SUBJECT: Engineering Review Comment  
Mountain View Electric Association Inc. (MVEA)

**Project Name: Kettle Creek Estates Filing 2 – Replat of Lot 1 Kettle Creek Estates**  
**Project Number: VR246**

Description: A proposed development of 2 residential lots located at Old Ranch Rd. and Otero Ave. in Township 12S, Range 66W, Section 28.

EASEMENT STATEMENT

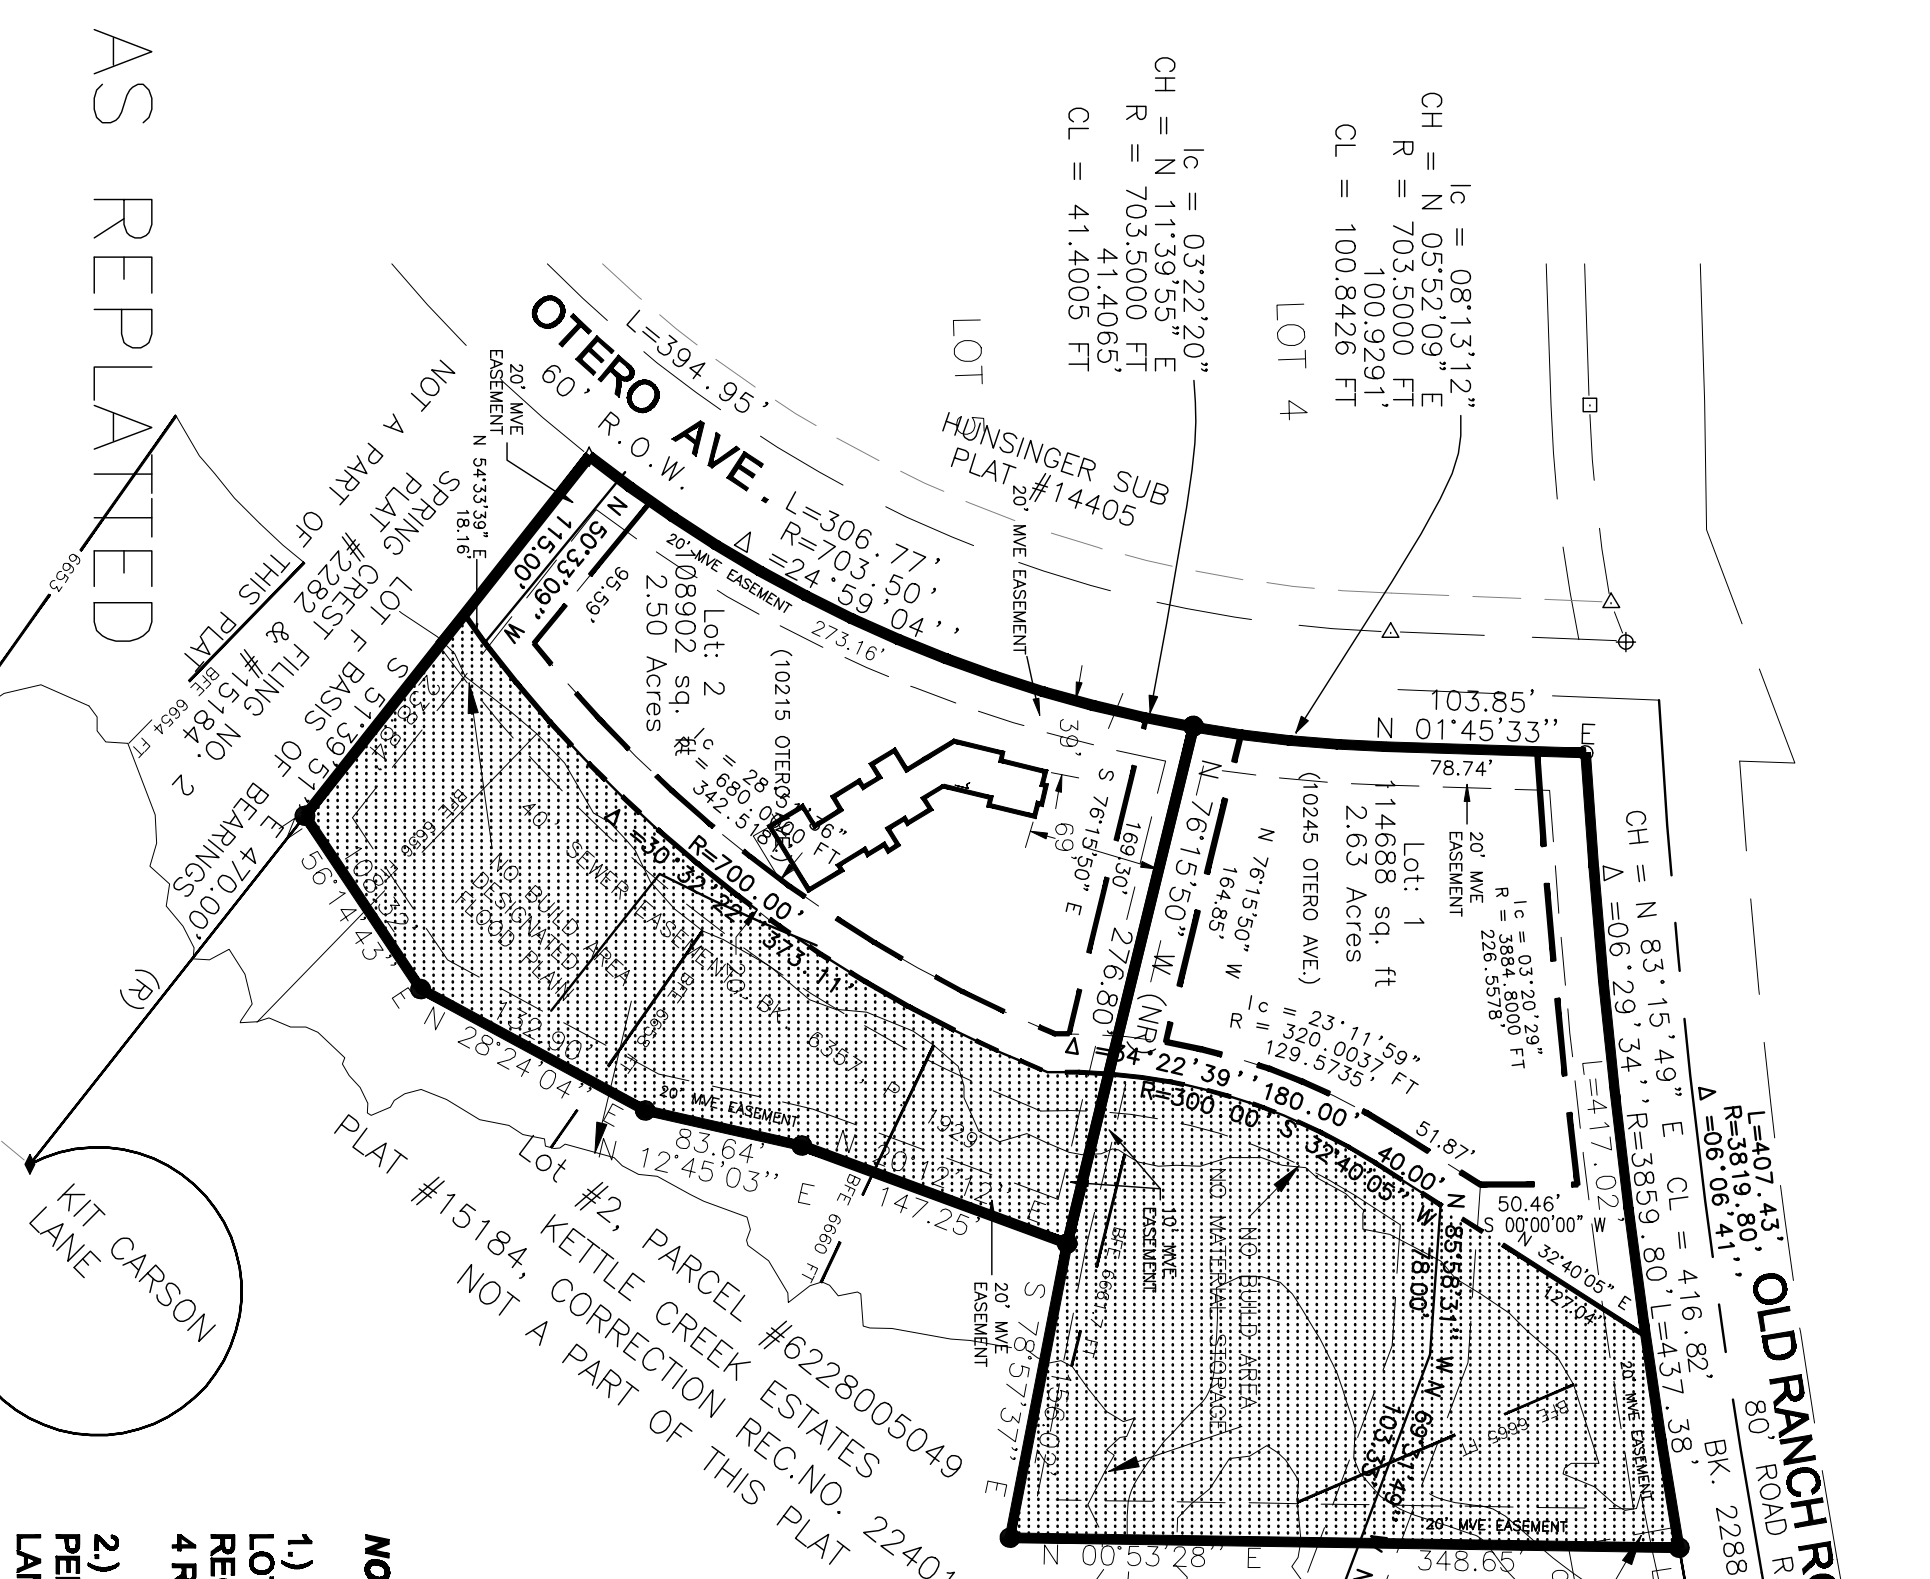
MVEA requests a ten (10) foot front, side, and rear lot utility easement and all tracts, along with a twenty (20) foot exterior utility easement on the plat. MVEA also requests the platting of MVEA's existing facilities with easements on the plat. Additional easements may be required.
